DARLINGTON PUBLIC SCHOOL
 SSD - 9914 ARCHITECTURAL DESIGN UPDATE

FOLLOWING RESPONSE TO SUBMISSIONS

GOLDEN GROVE STREET, DARLINGTON, SYDNEY
 Department of Education

Project Name		Darlington Public School	
Project Code		DTPS	
Document Name		SSD-9914 Architectural Design Update	
Revision	Date	Comment	Approved
REV 00	20.08.20	Design Change Report	EC

14 Perspective Cutaway FT07
NTS

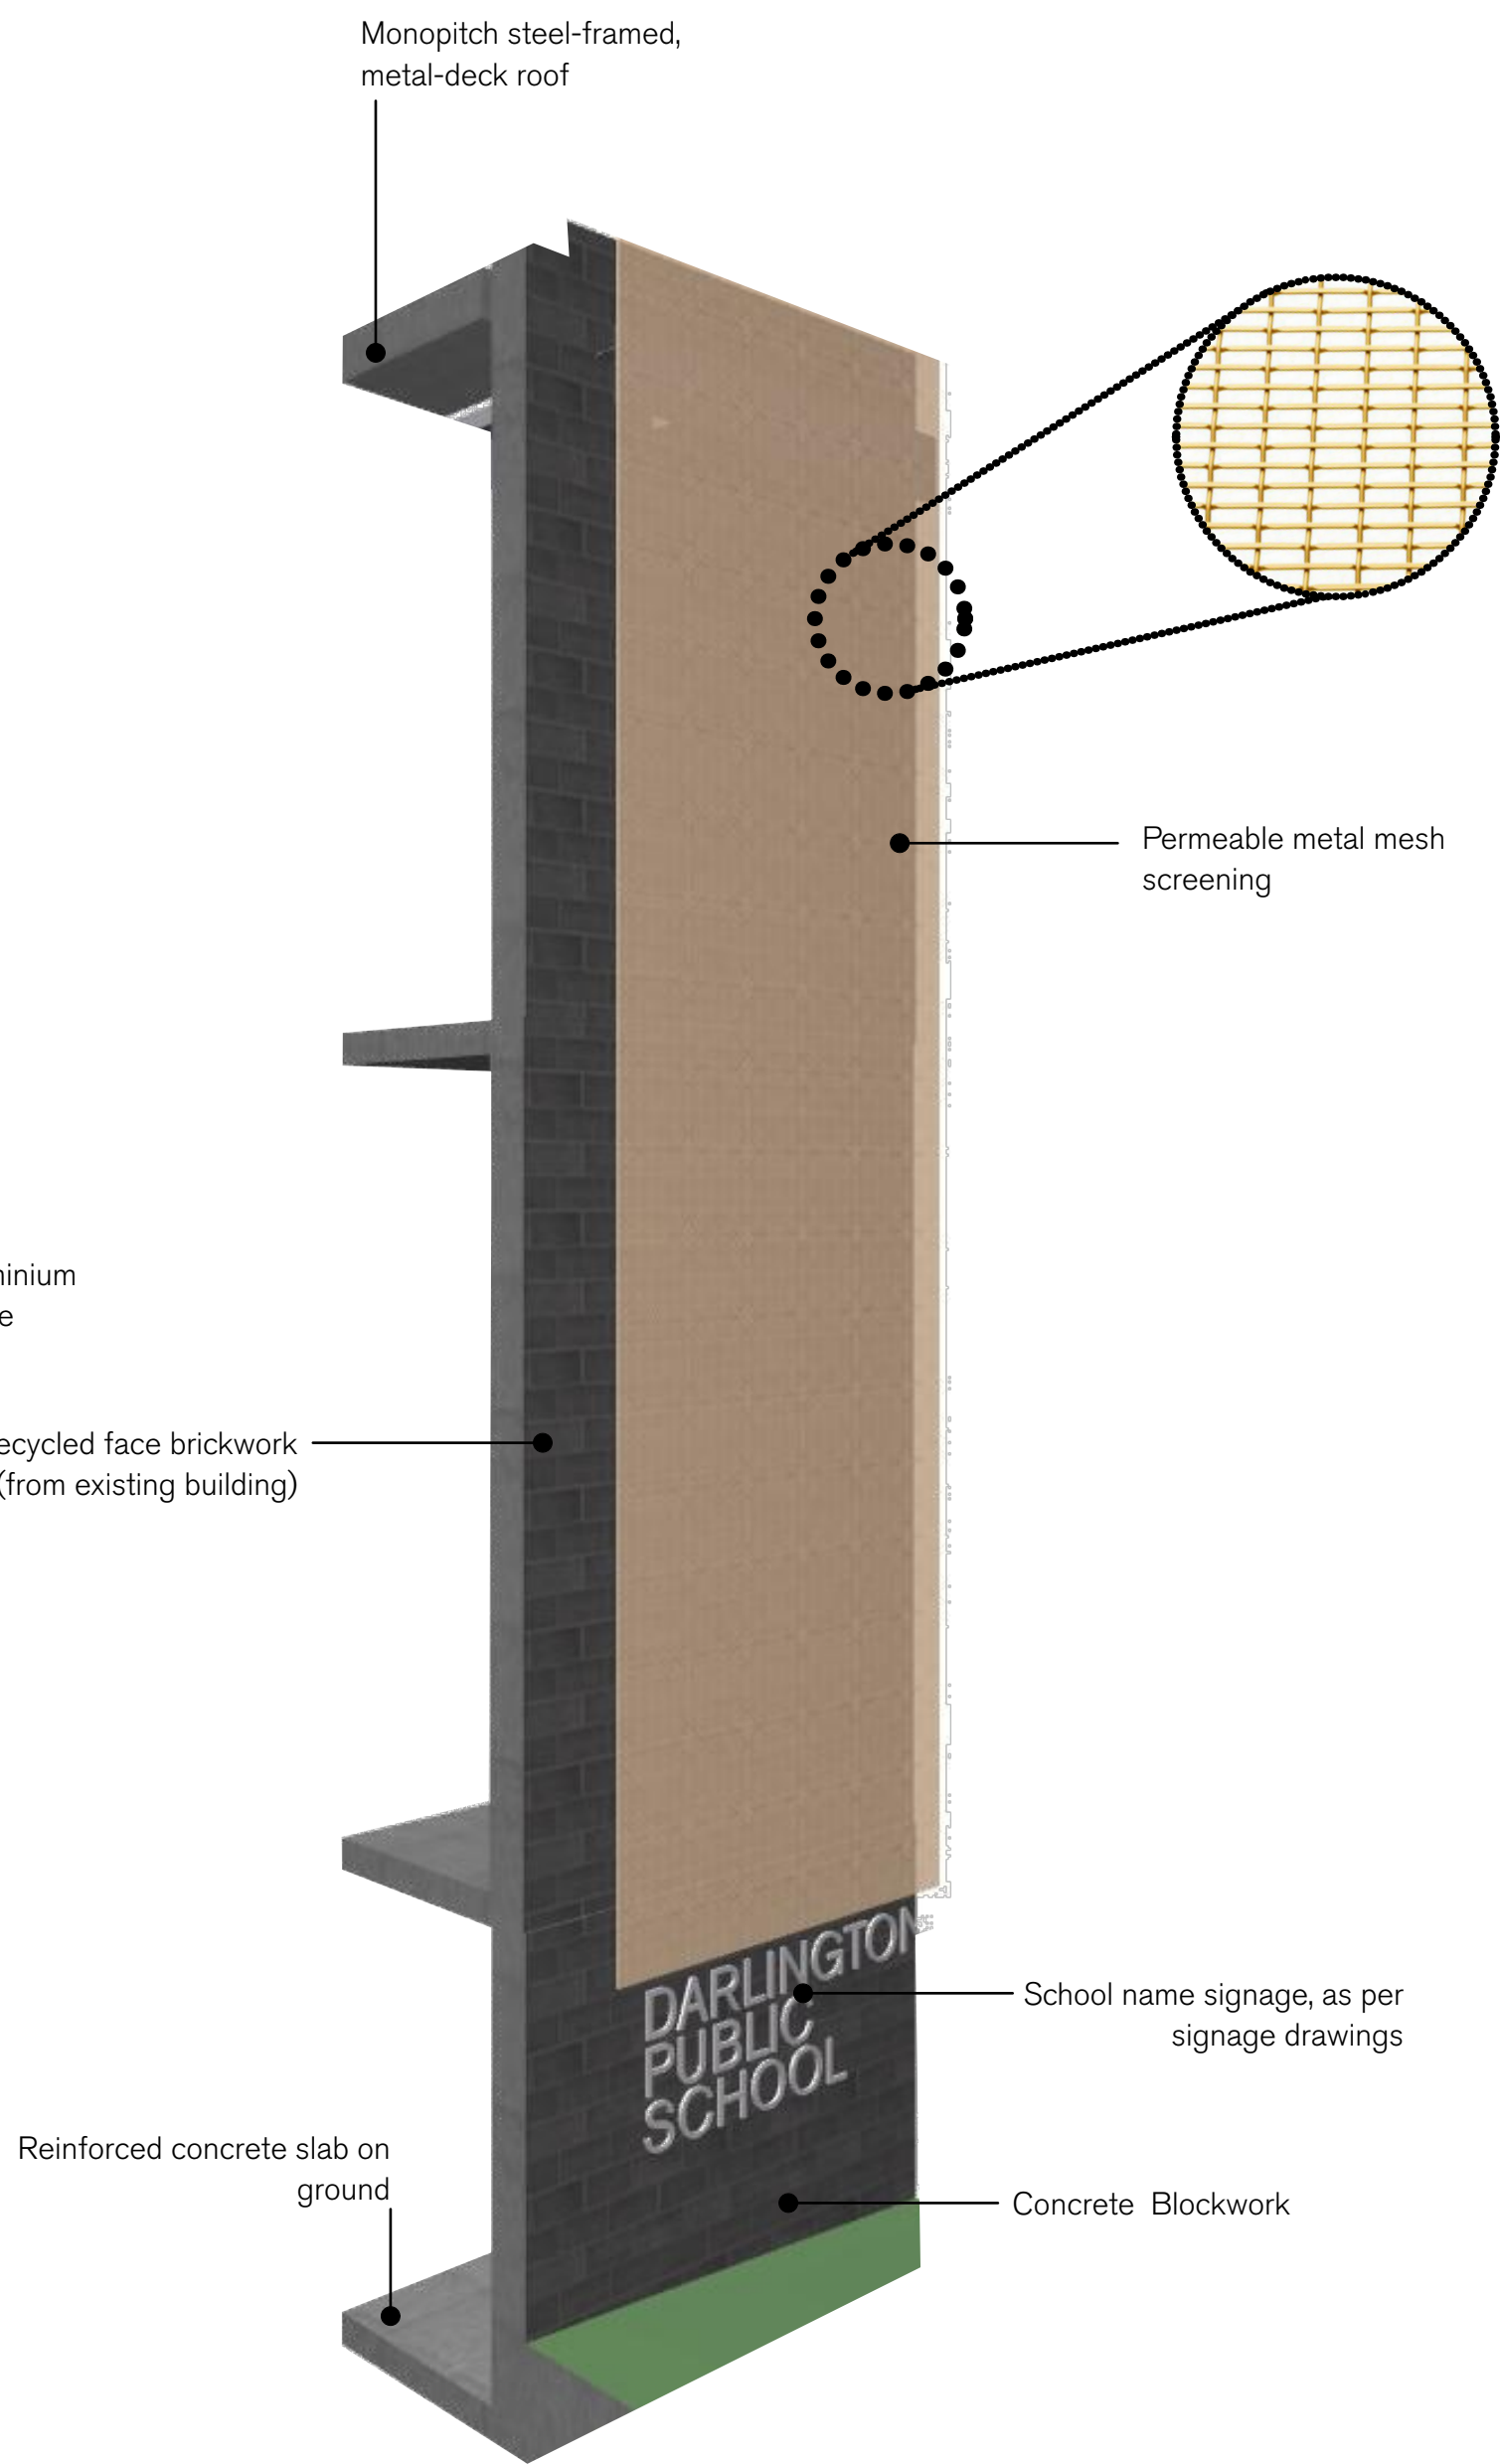
2.0 Articulation of the Southern Facade

- The glazing and brickwork to the southern facade of the hall building has been articulated to provide a finer grain response to the streetscape.
- The previous single large window into the south facade of the communal hall has been divided into 5 smaller windows. These are set into a recessed brick facade with large splayed sills and clearly defined brick blades between the glazing elements.
- This creates a more interesting street frontage, responding to the local context and a more structurally efficient result.

title
Perspective Sections - Facade Eastern Facade - FT04, 05, 08

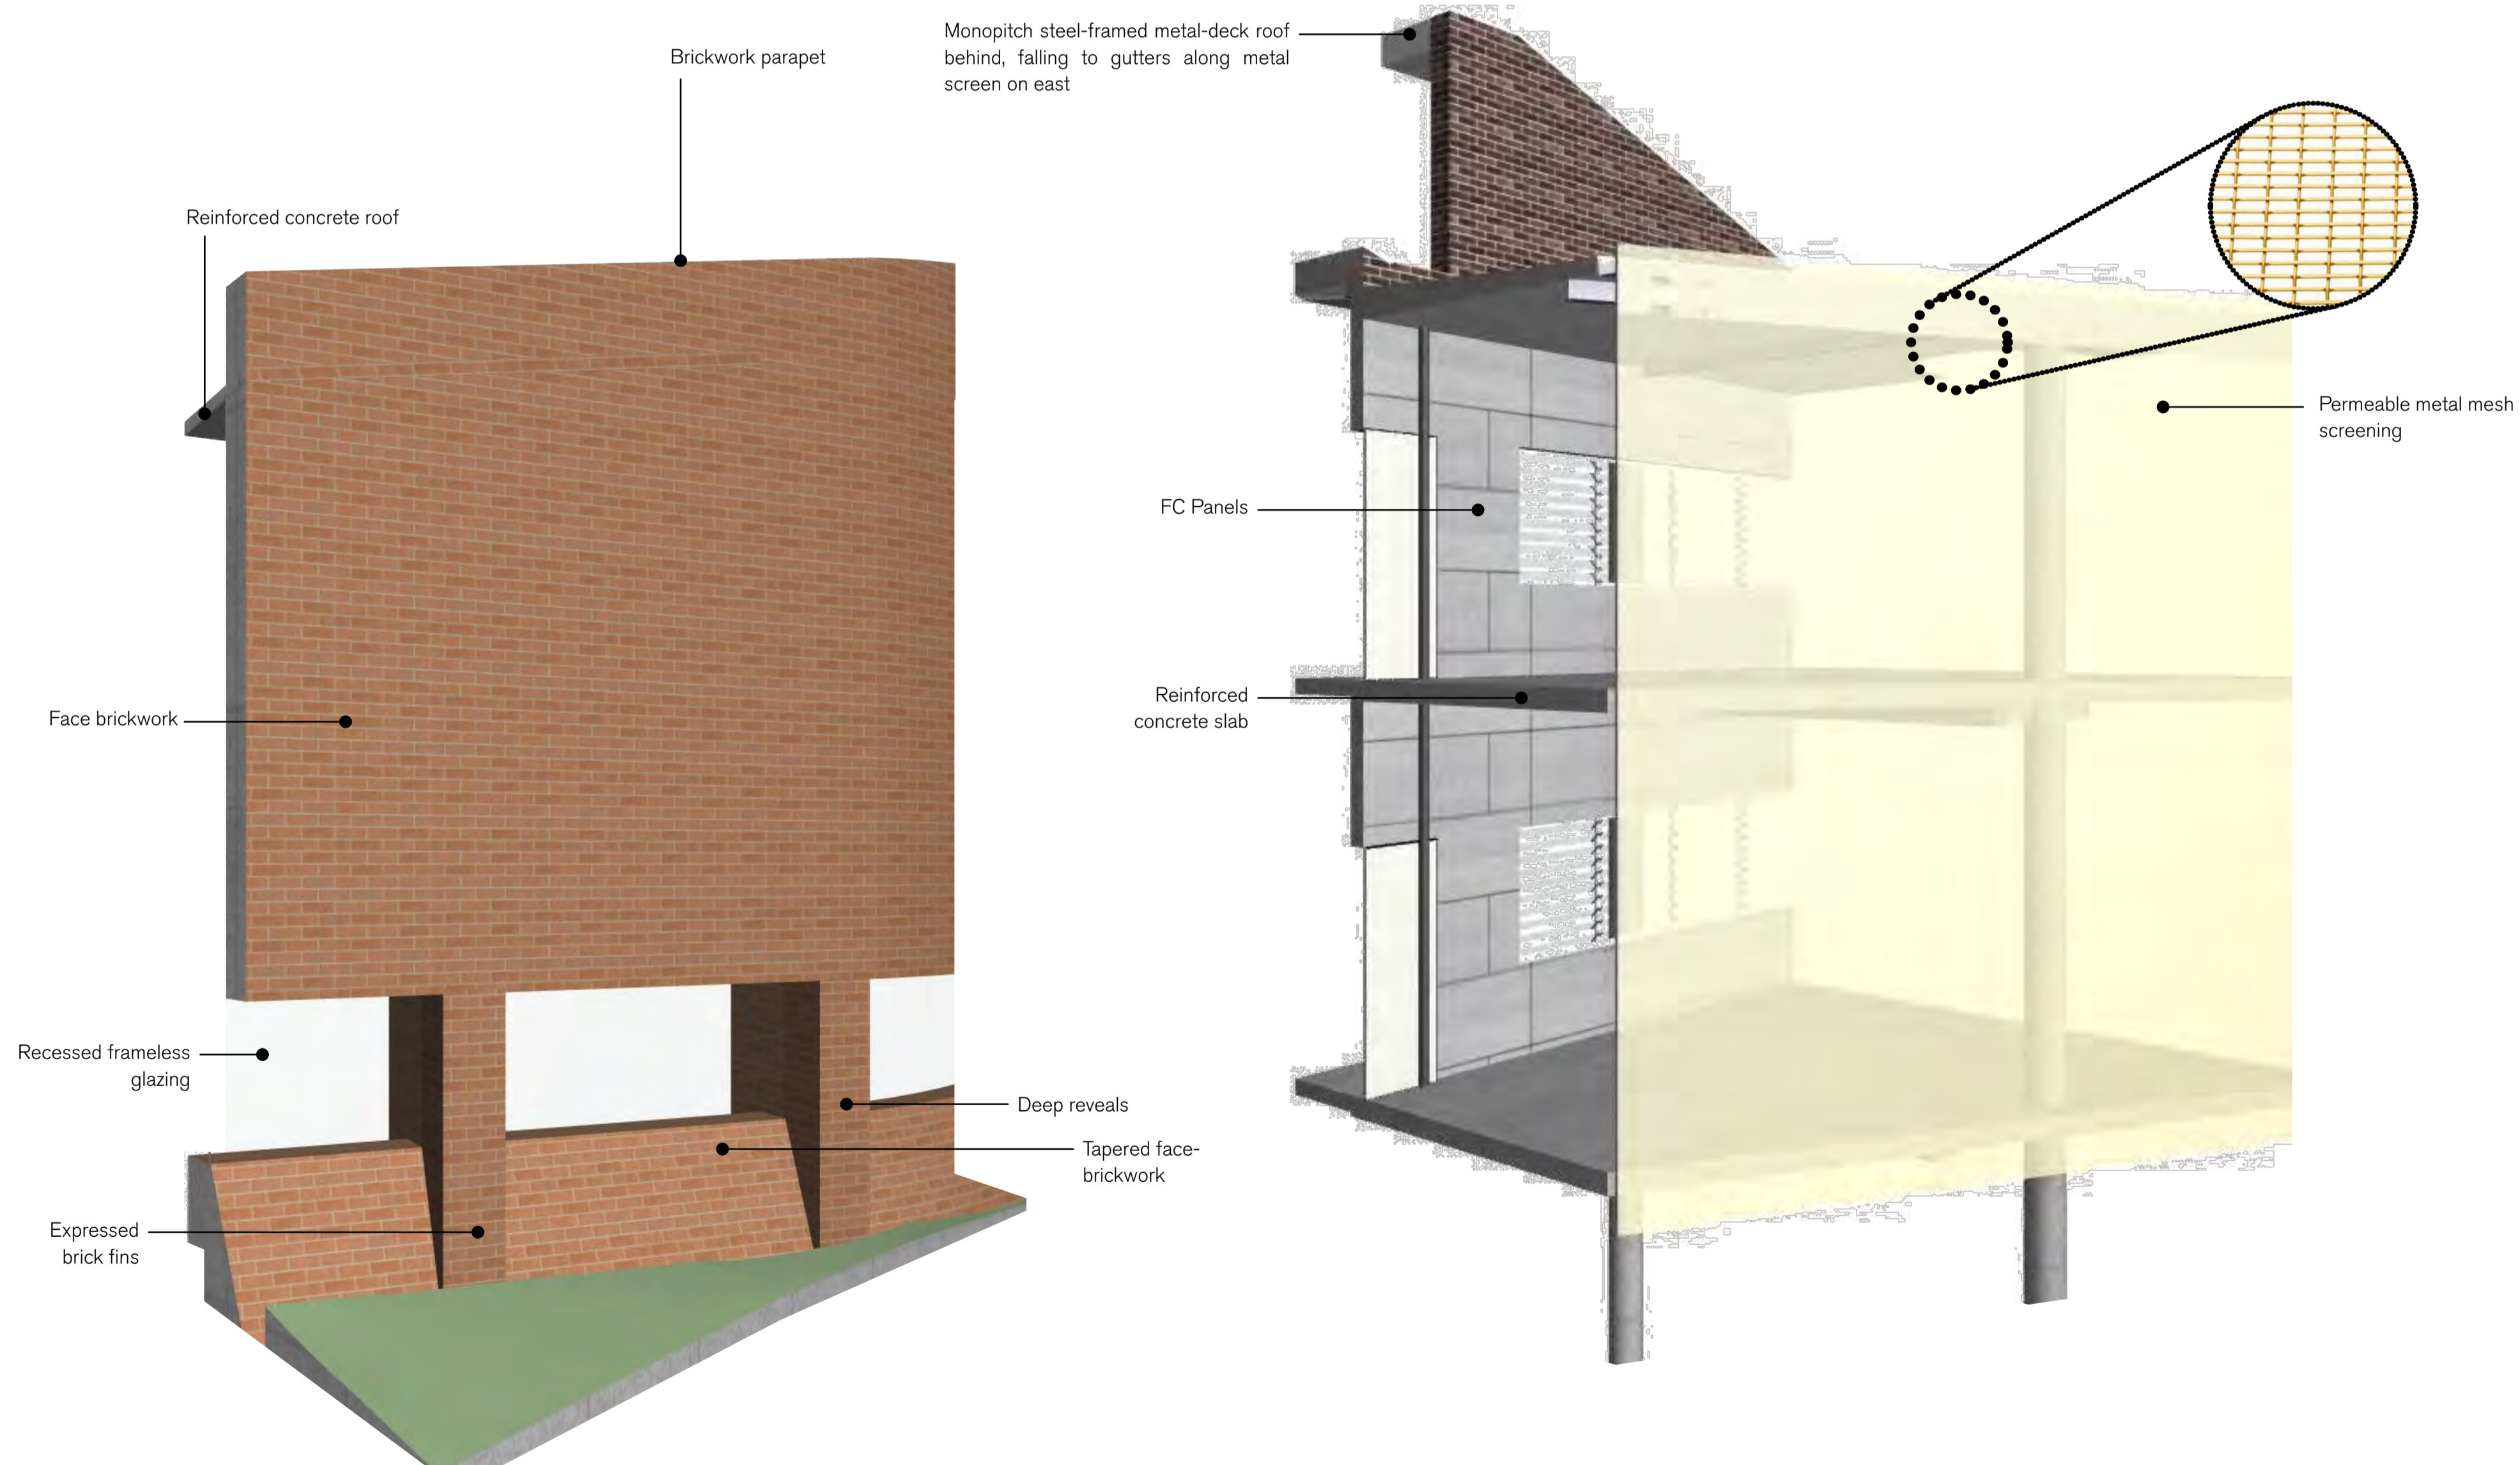
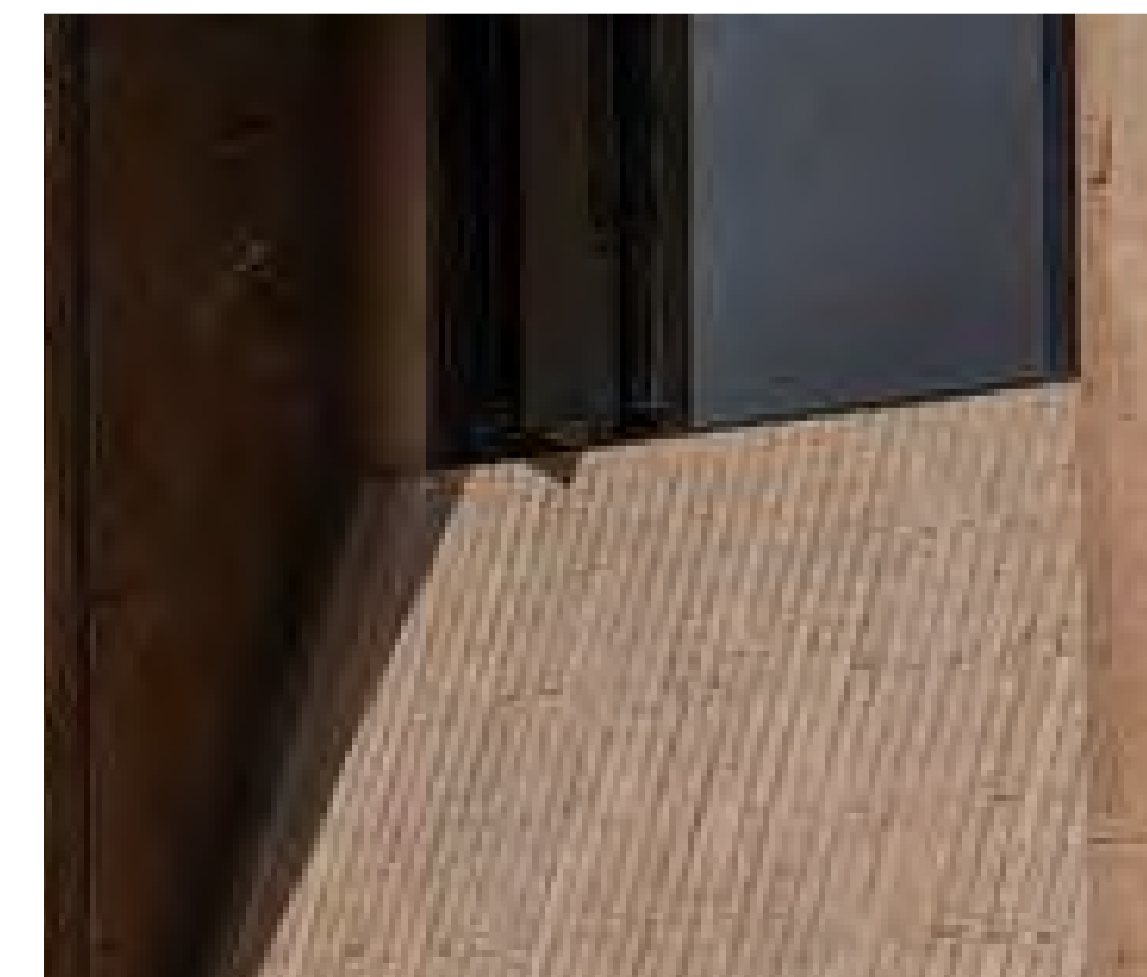
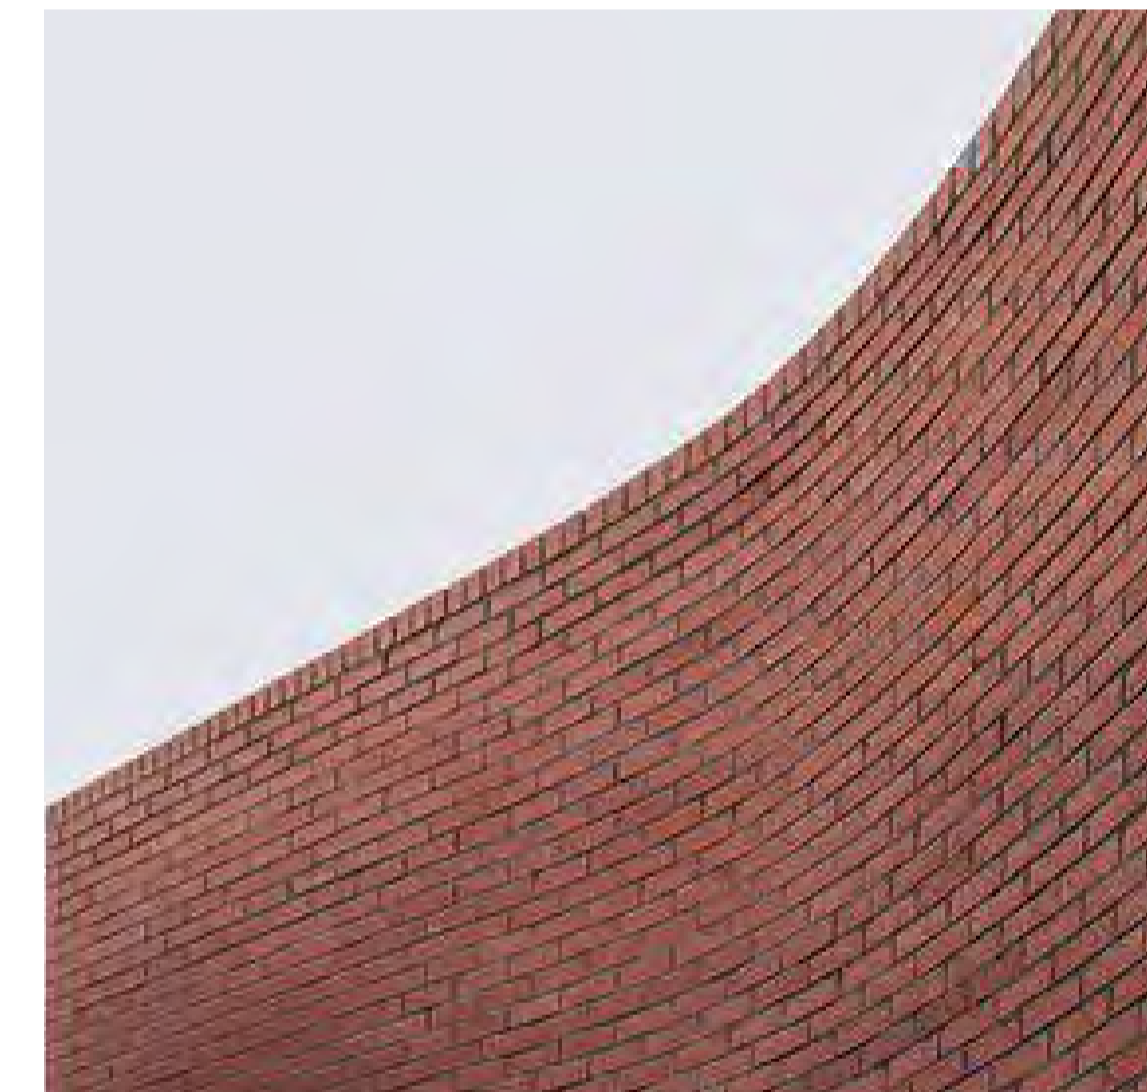
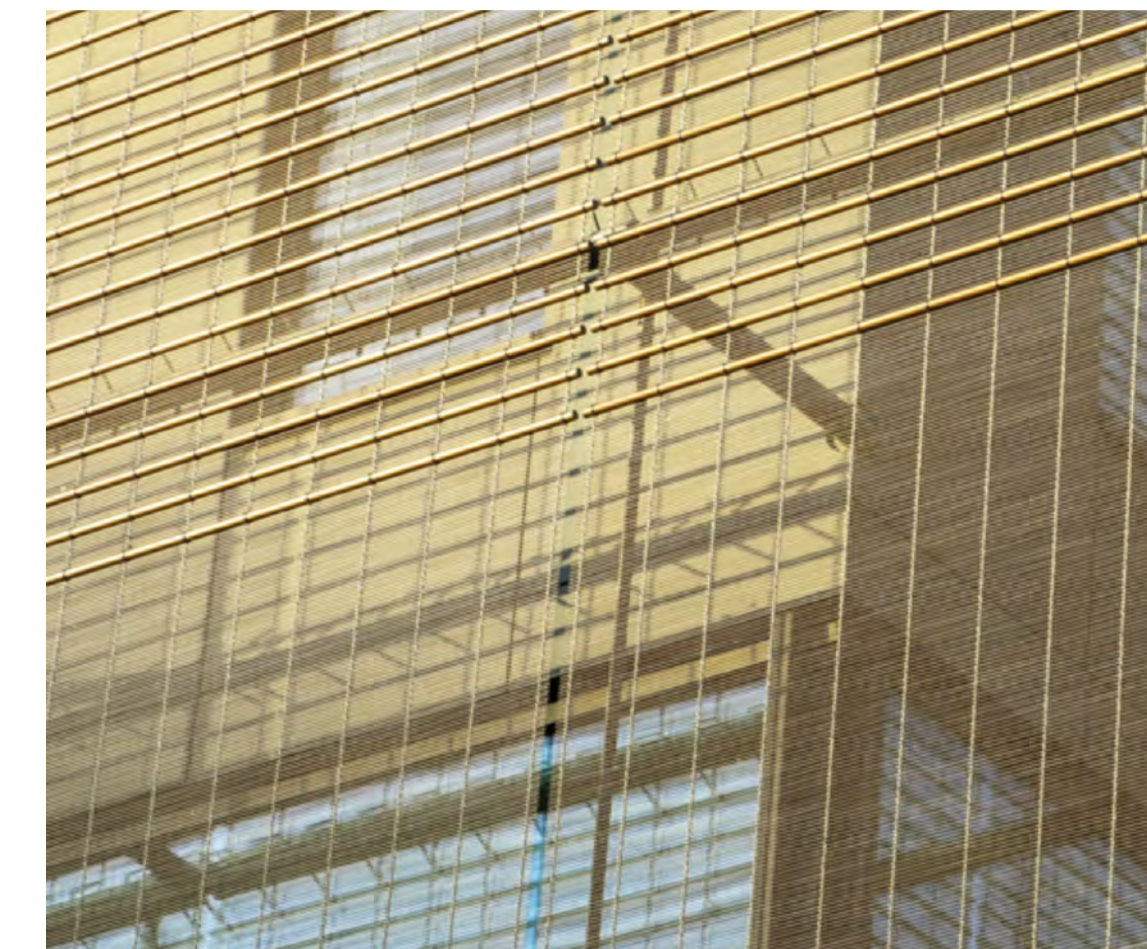
3.0 Reduction in bulk of the south-eastern wing

- Due to the large volume above the hall, it was decided that the staff area could be moved from the east wing, to above the hall. This has resulted in a reduction in height and bulk on the eastern side of the hall whilst still holding a strong alignment to the street through both the lower form and landscaping.
